RECORD OF PRE-DEVELOPMENT ADVICE

Proposal: Central Coast Quarter - HDA Scheme
Property: 26–30 Mann Street, Gosford, NSW
Application: SSD-90960208

Council refers to the public exhibition of the Central Coast Quarter – Housing Delivery Authority (HDA) Scheme, being State Significant Development Application (SSD-90960208), and provides the following submission.

Figure 4 North elevation

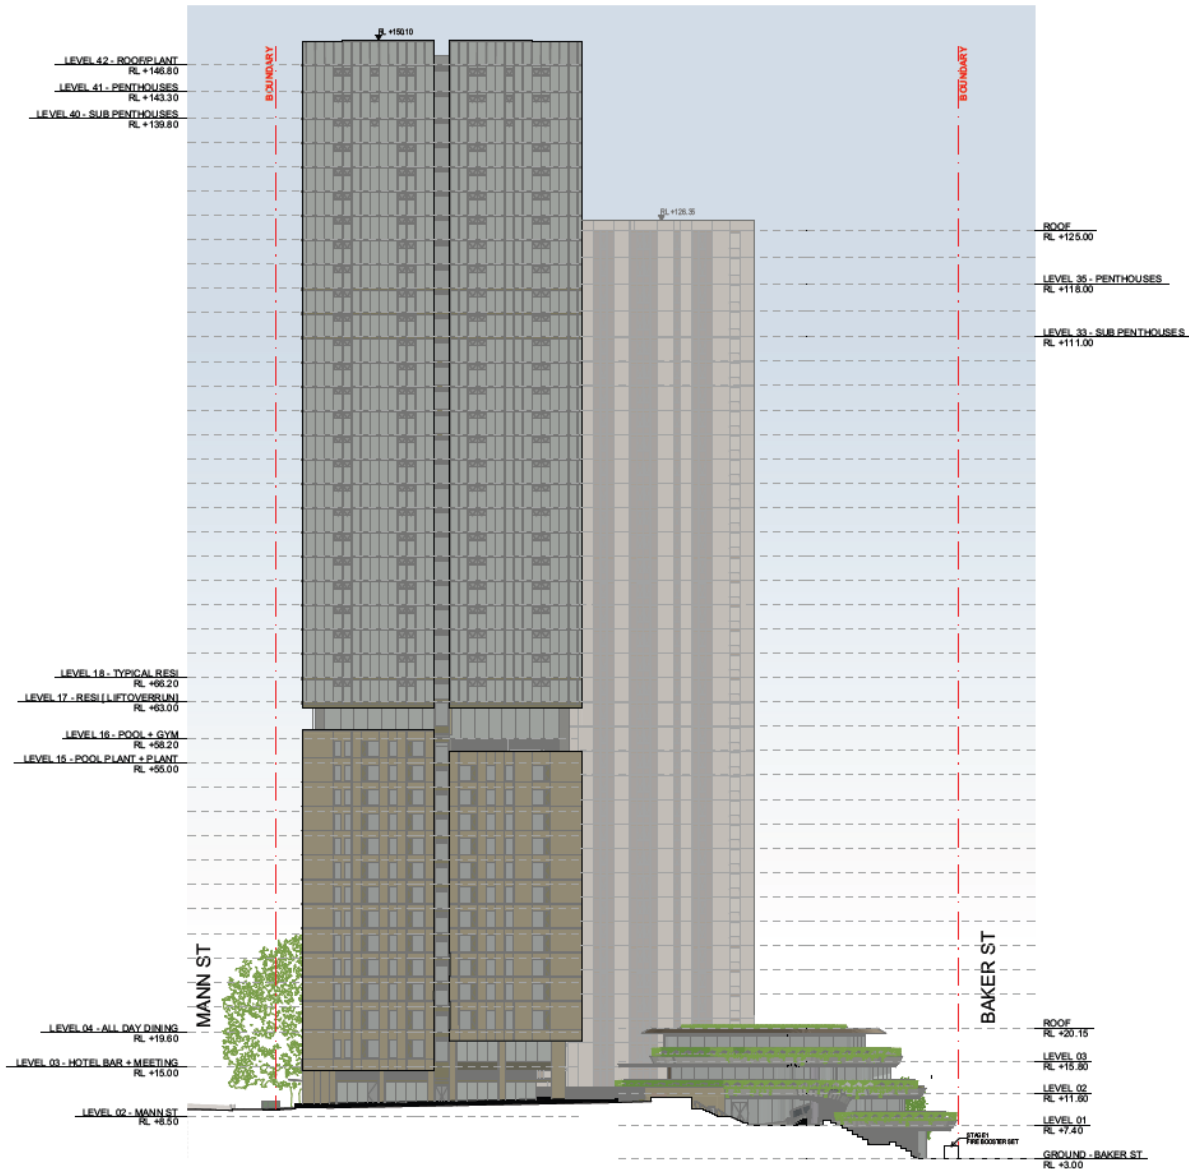
Council also has concerns regarding the dominance of the southern tower, particularly in its relationship to Memorial Park and the foreshore. In Council's view, the current height and bulk do not sufficiently demonstrate a balanced or stepped built-form outcome. Council considers that alternative massing strategies—such as reducing the height of the southern tower and redistributing floor space—could substantially improve solar access, visual scale, and public domain outcomes.

- The southern tower is perceived as overly dominant in both height and bulk, particularly given its foreshore and park interface.
- Insufficient differentiation between tower forms reduces the effectiveness of the stepped height strategy originally intended to moderate visual and environmental impacts.
- Council considers that alternative massing arrangements—such as redistribution of height between towers or reduced southern tower height—could materially improve outcomes.
